Application for removal or variation of a condition following grant of planning permission.

DEMOLITION OF FORMER BRITISH LEGION CLUB BUILDINGS & ERECTION OF
6 DETACHED BUNGALOWS AND ACCESS ROAD - RE SUBMISSION OF
Hox-0420-20

THE APPROVED POSITION OF THE BIN STORE WITHIN PLOT 6 IS INHIBITING
THE SALE OF THE PLOT 6 BUNGALOW

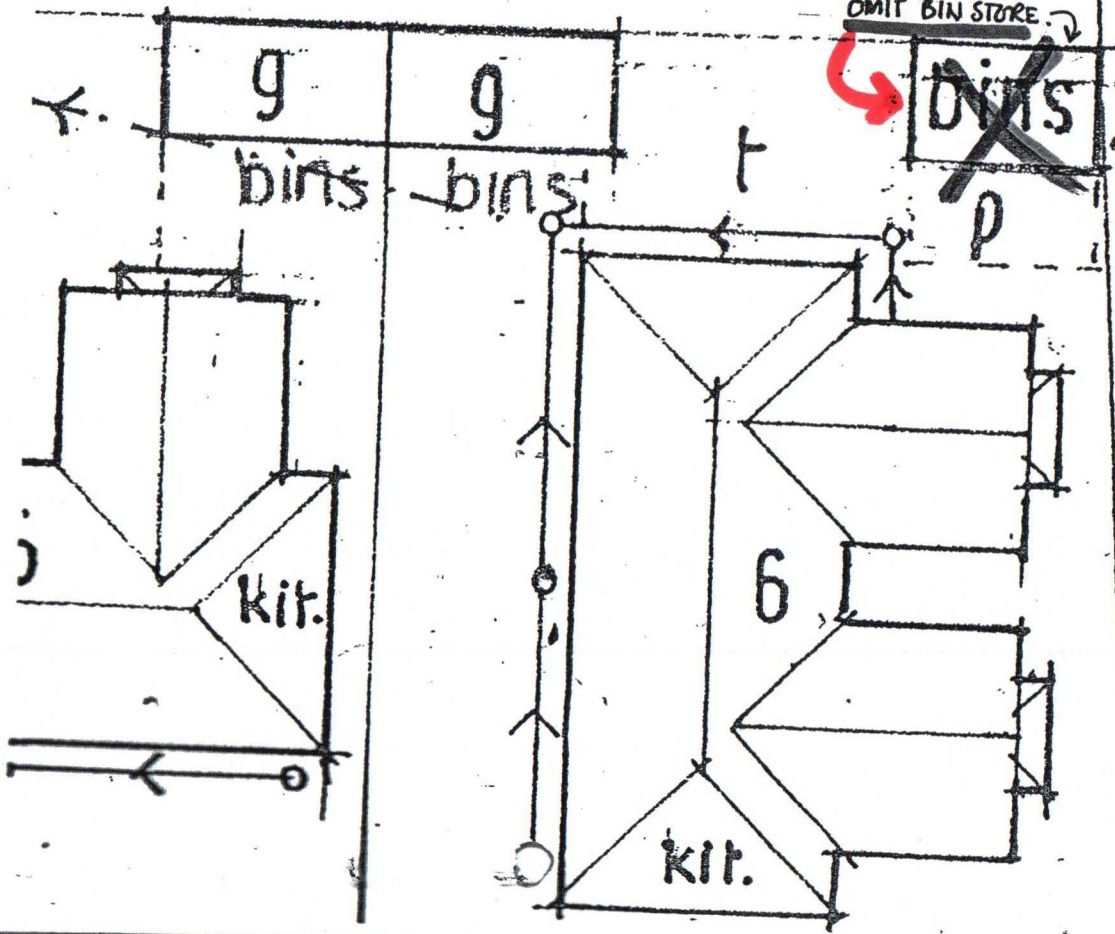
WE WISH TO RESITE THE BIN STORE (AS TO BUILDING CONTROL'S
CONFORMED APPROVAL - ON THE OPPOSITE SIDE OF THE ACCESS ROAD
SEE ATTACHED SKETCH.
